Bloxham Parish Council **OBJECTS** to application 19/01705/OUT on the following grounds.

DESIGN INFORMATION	
Design stage	Feasibility
Description of Highway Infrastructure	Simple priority T junction
Checking Authority	County Council / Unitary Authority
Design Codes	MFS & LTN 1/07
Description of Ground Conditions	Not known at this stage

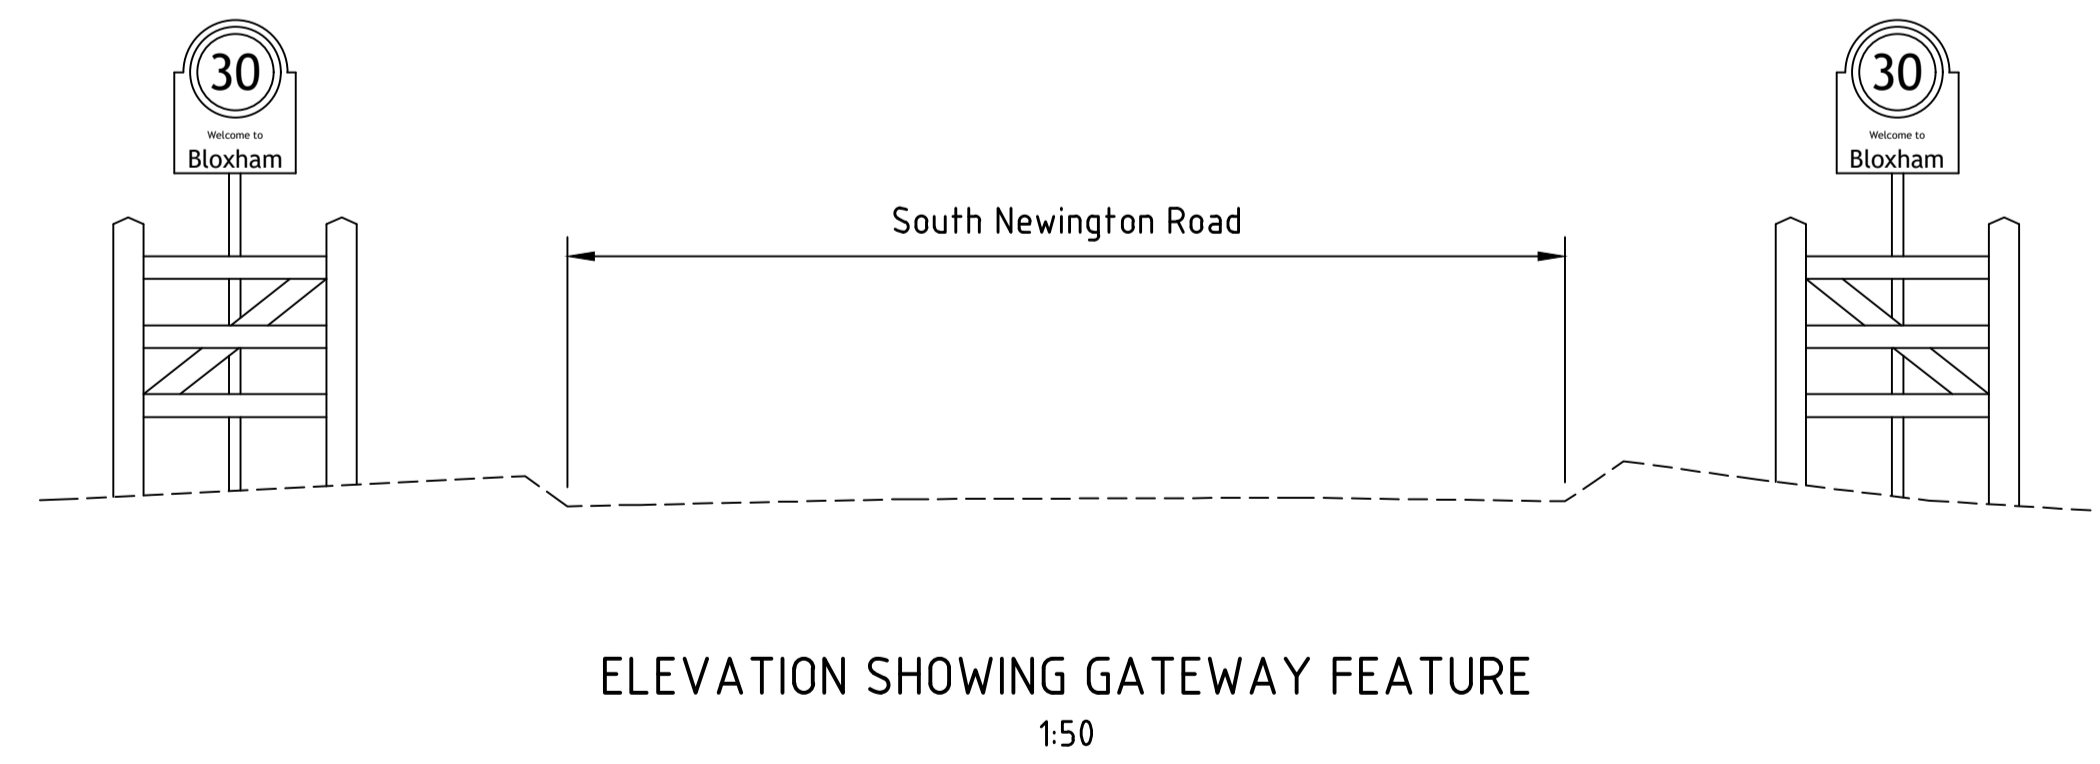
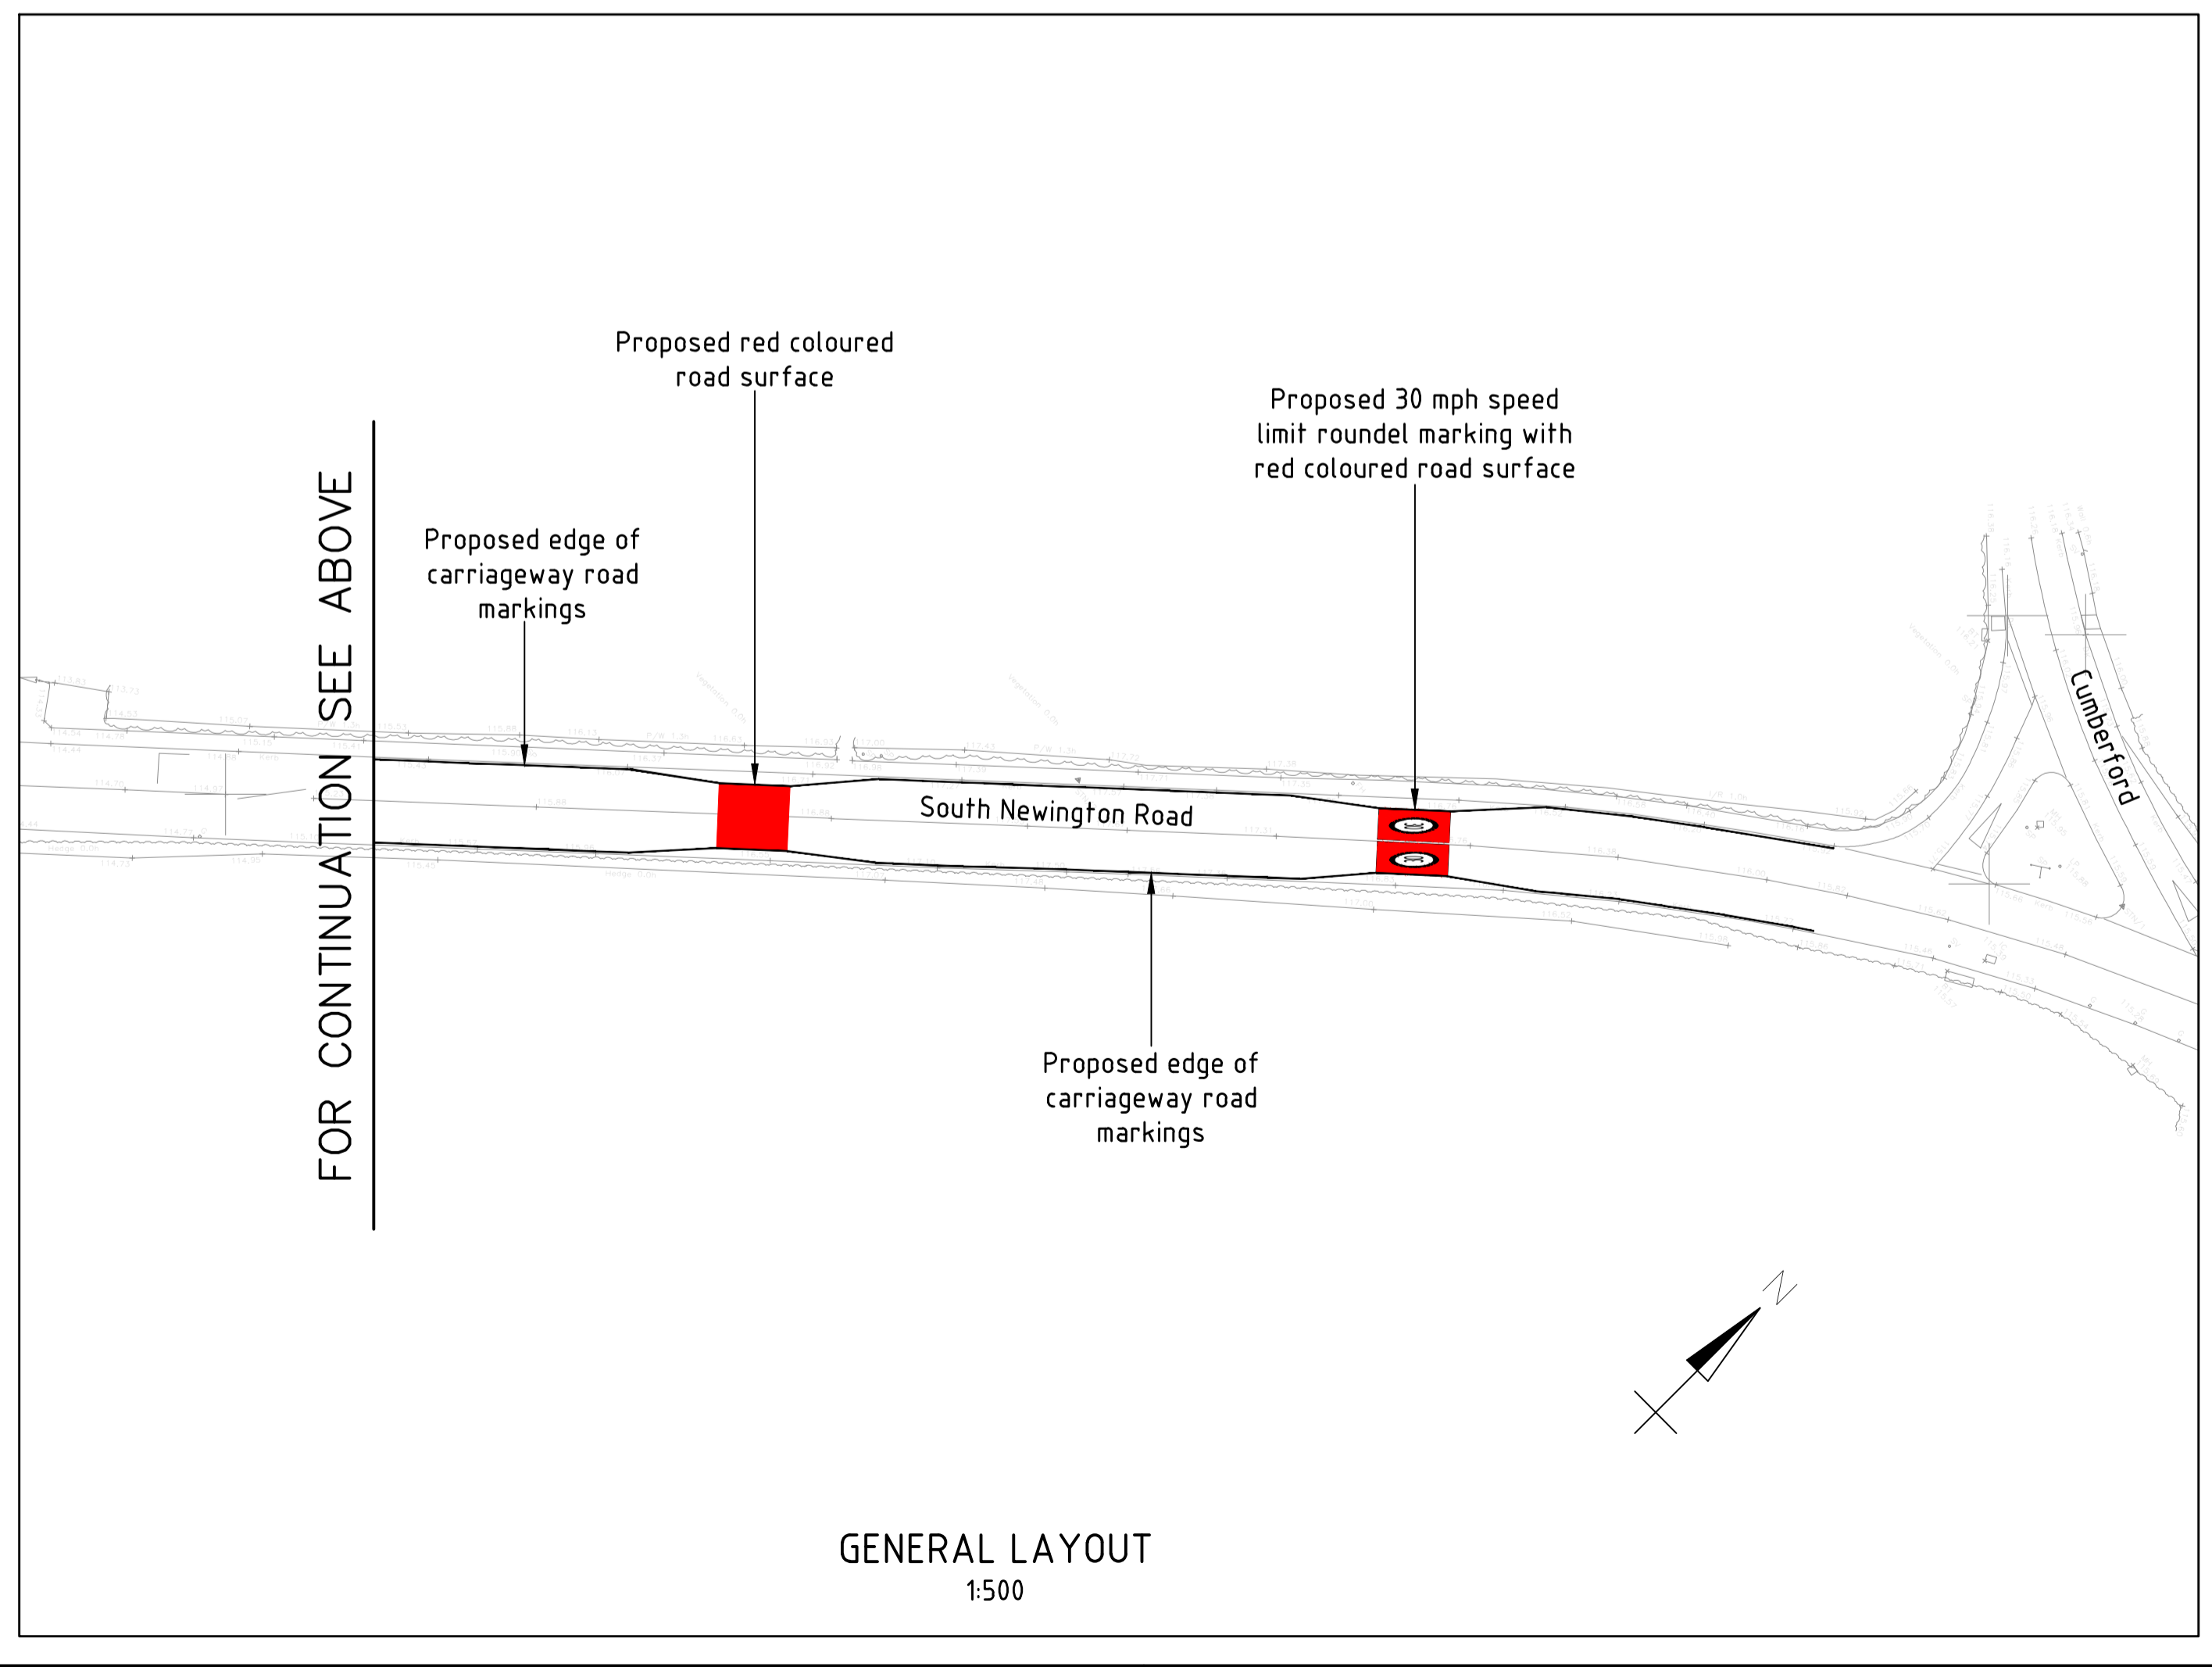
NPPF para 84: Traffic is at capacity at the South Newington roundabout with no feasible way to increase it according to OCC. In addition, speed coming into Bloxham from South Newington will make the new junction dangerous, and putting 30mph roundels on the road is not going to help. Other impacts include the Slade and the flooding on the Rec

NPPF 108(c): A361 traffic through Bloxham already causes significant delays and heavy congestion. The new development proposes to join the A361 directly, creating a very dangerous junction given speeds in that area. The proposed mitigation of drawing dragons teeth and 30 mph roundels is totally insufficient in terms of mitigation.
